Norfolk Vanguard Offshore Wind Farm

Applicant: Norfolk Vanguard Limited
Document Reference: ExA;DCOSchedule;10.D2.6
Revision: Version 2

Schedule of changes to the draft DCO
(For Deadline 4)

Title: **2.4 Works plan (onshore) (sheet 21 of 42) (January 2019 Revision)**

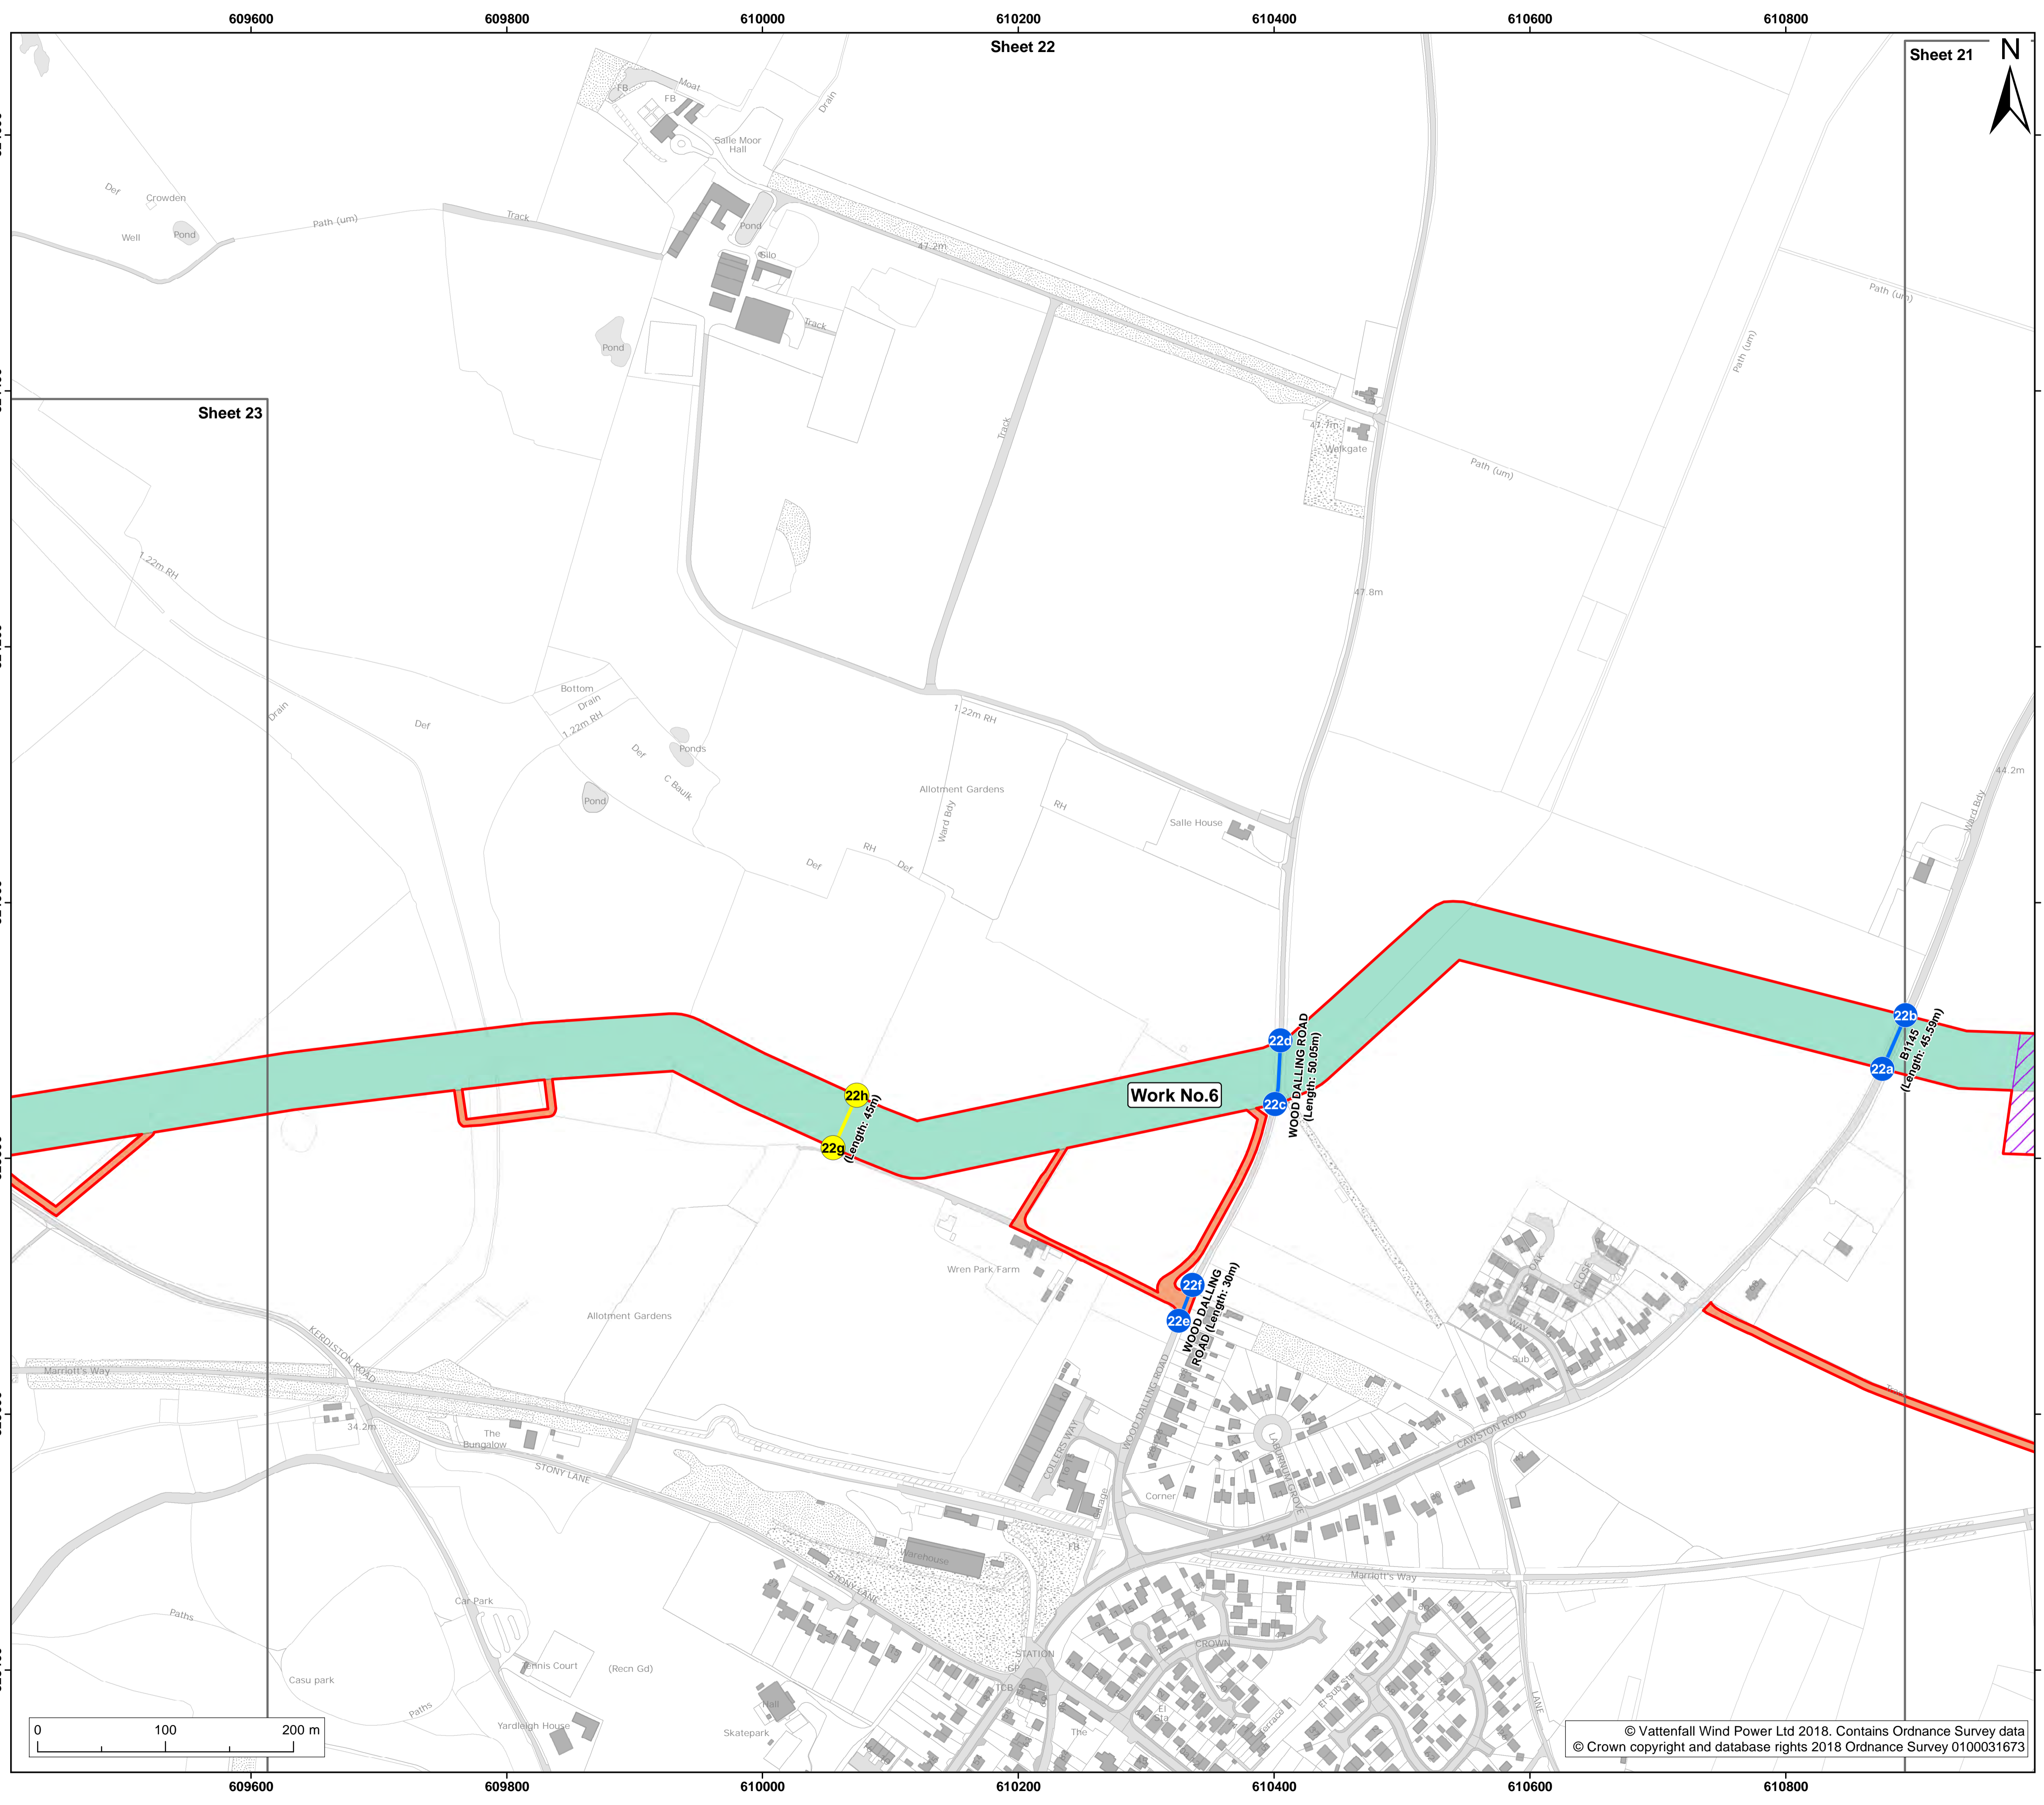
5.	Schedule 4	PINS (s51)	Sheet 20 of 42 of the plan showing streets to be temporarily stopped up (Doc 2.07) illustrates the stopping up of an unidentified private road 59.52m in length between '20a and 20b'. However, Schedule 4 of the draft DCO does not have a listing for this description.	Schedule 4 of the draft DCO has been amended to refer to ' Approximately 60 meters of Private track as is within Work No.6 as shown on sheet 21a and 21b on sheet 21 of the streets to be stopped up plan ' within the District of Broadland.	2
